Application for a non-material amendment following a grant of planning permission. Town and Country Planning Act 1990

change of use of former library & headmaster's house to a single residential dwelling, including replacement of existing single storey rear extension, demolition of existing shed, refurbishment and conversion of existing outbuilding to office (gym and provision of off street parking to front (part retrospective)

22/503773/FULL

222/08-17A

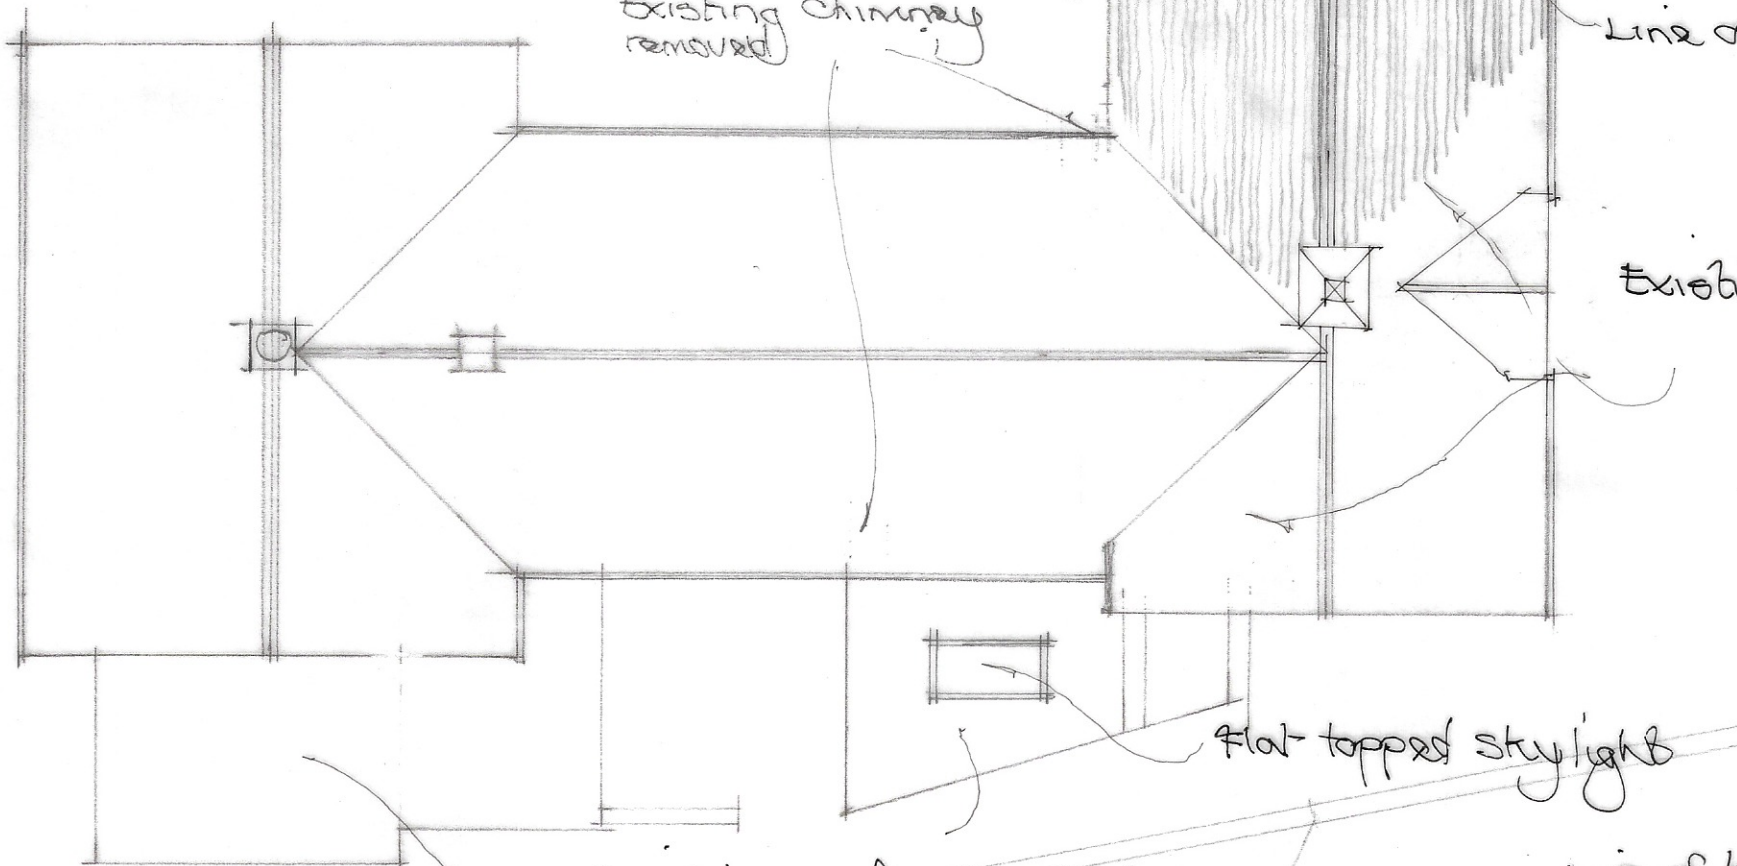
Retrospective application for the removal of 2 no. side chimneys full height, including removal of 1 no. internal chimney breast - Both chimneys redundant

Existing Redundant & poor quality chimneys to rear/side elevations removed to enhance construction & roof finishes
